KITITAS COUNTY

MEMORANDUM

TO: All Staff
FROM: Public Works Plan Review Team
DATE: November 23, 2021
SUBJECT: BL-21-00026 Powell

The Public Works Department has reviewed the Request for Boundary Line Adjustment Application.

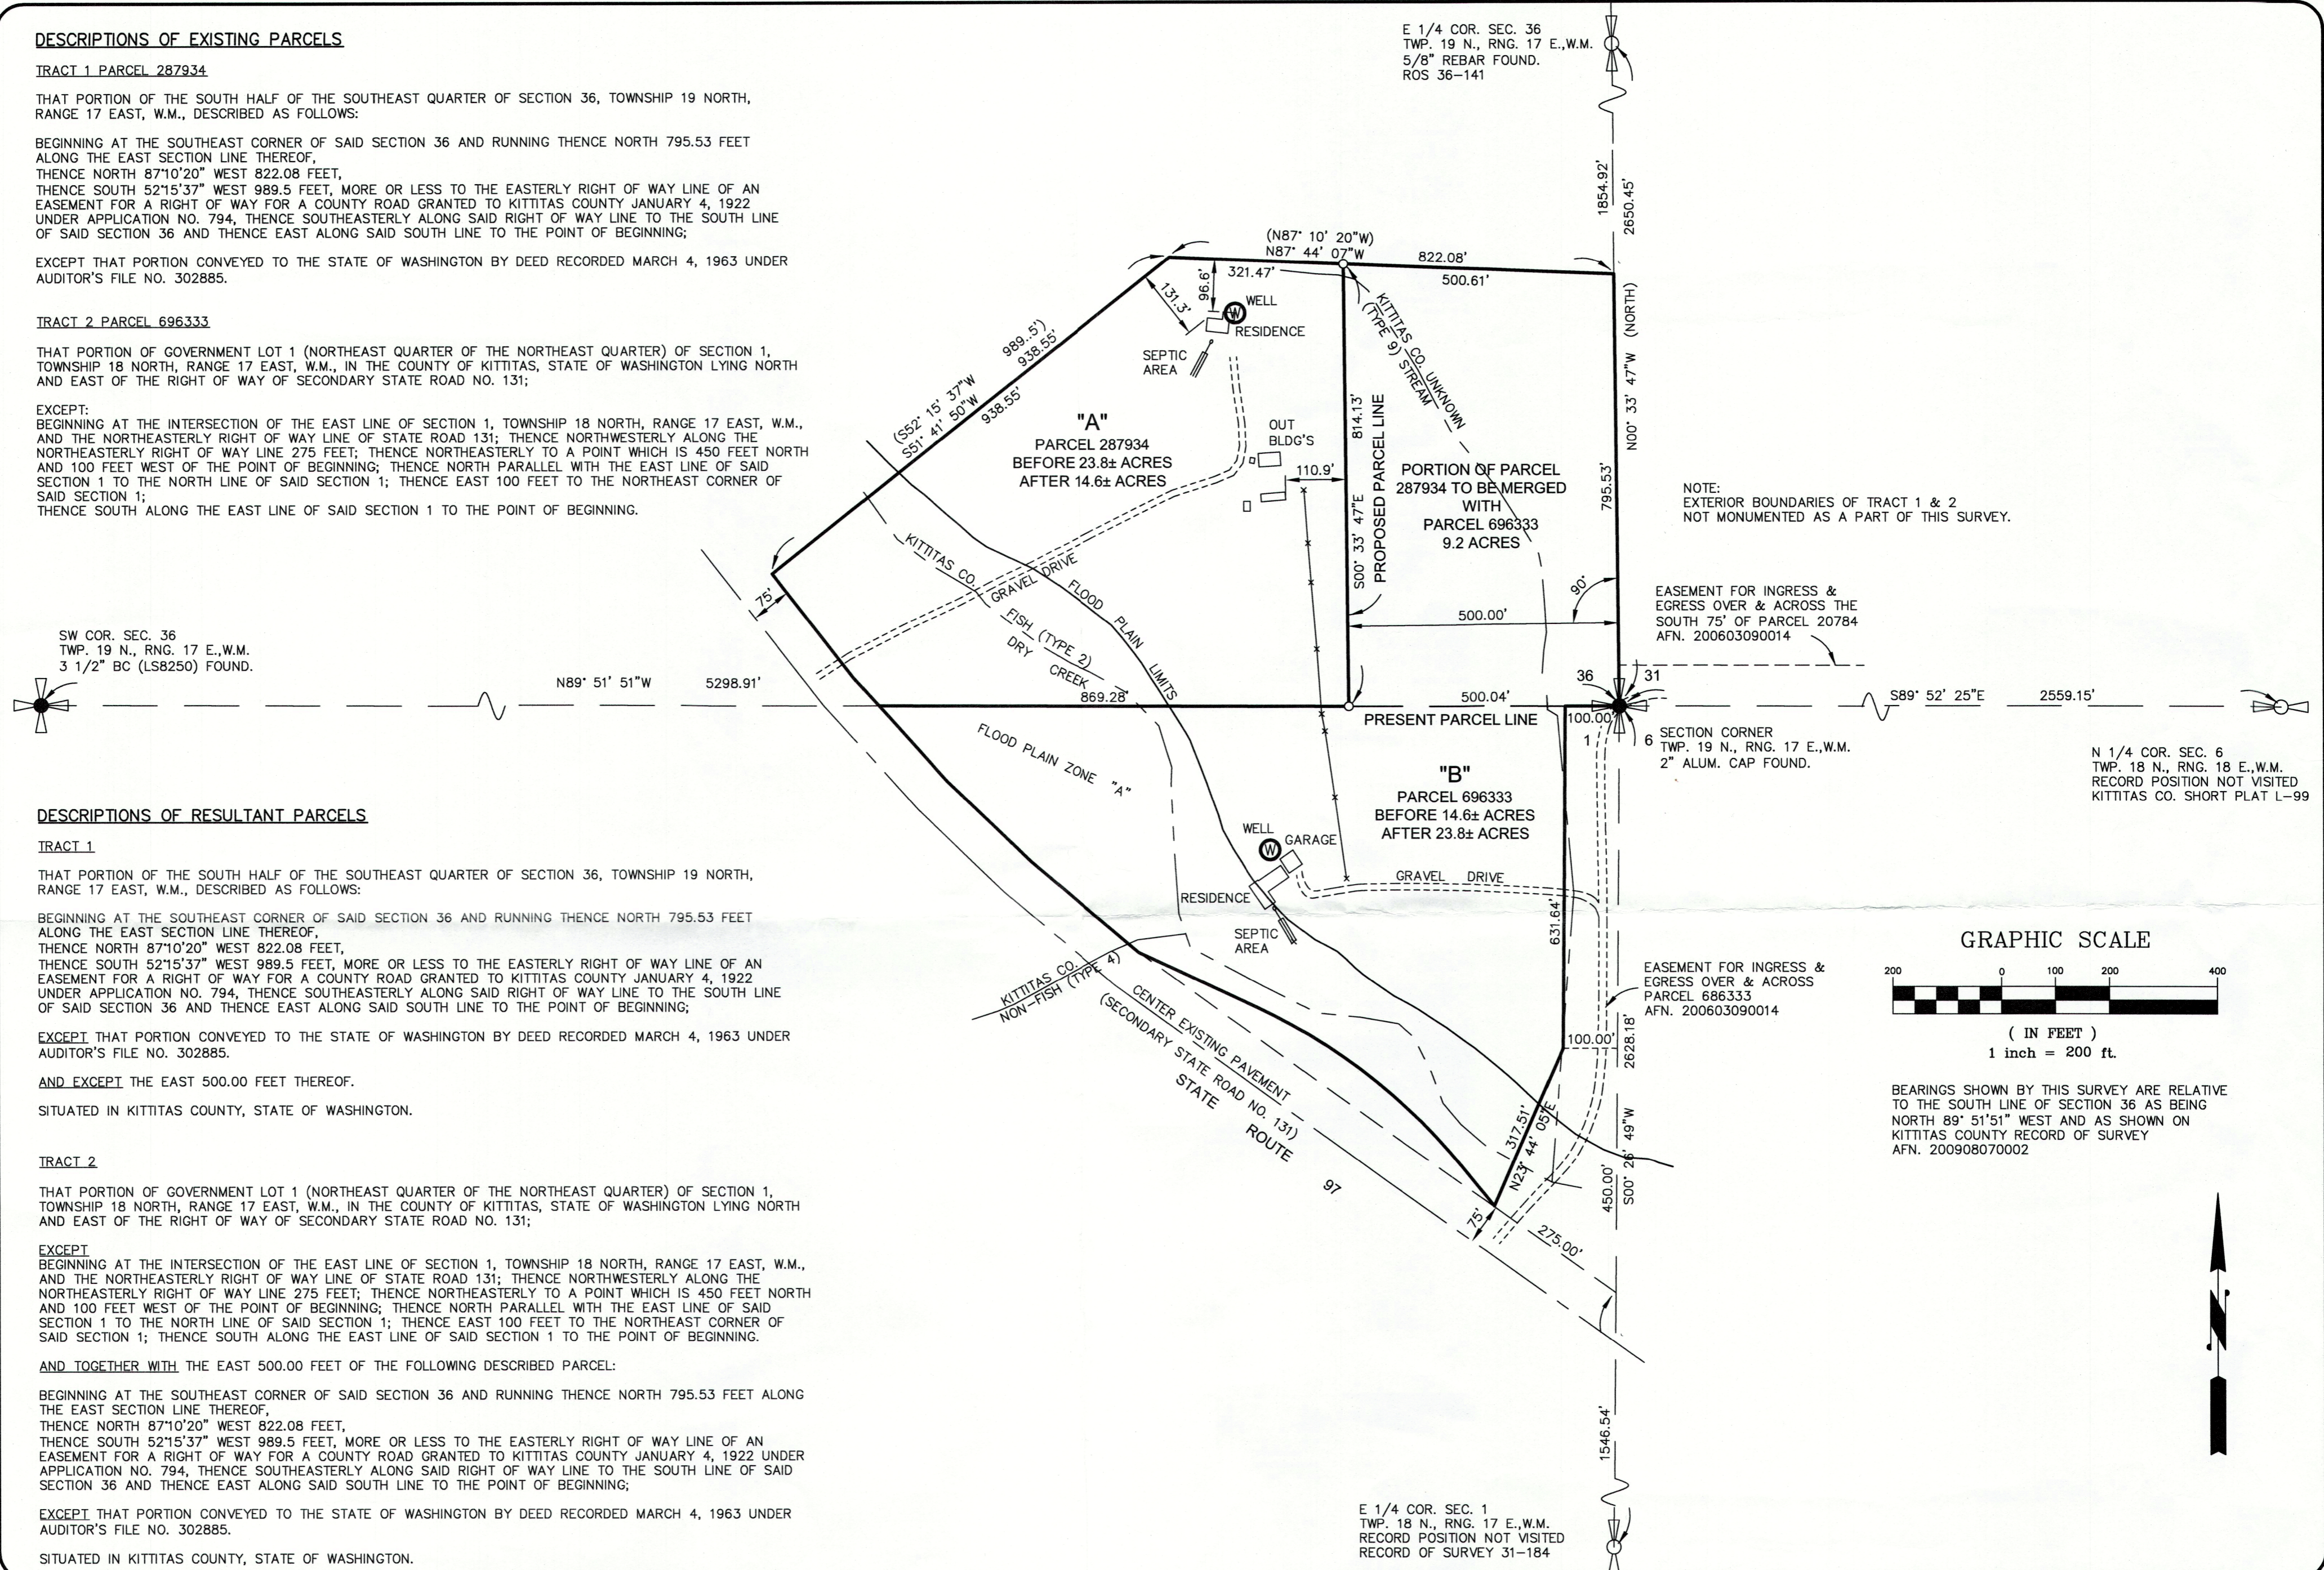
1. Please include a reference note containing the purpose of the survey, together with the application number. (EX: The purpose of this survey was to satisfy the conditions of approval for a Boundary Line Adjustment submitted to Kittitas County, under Application BL-21-00026.)
2. Please show Section, Township and Range at top center of Page.
EX: RECORD OF SURVEY
Portion of SE1/4 SEC. 36, T19N., R17E., &
Portion of NE1/4 SEC. 1, T18N., R17E., W.M.

3. The bearings and distances for the boundaries adjacent to State Route 97 are missing.
4. Please show the Name, Ownership and surfacing for the Easement "AFN:200603090014" (EX: Cross Creek Drv. - Private – Gravel)
5. The bearing for the E line of Sec 1 is obscured by crossing linework.
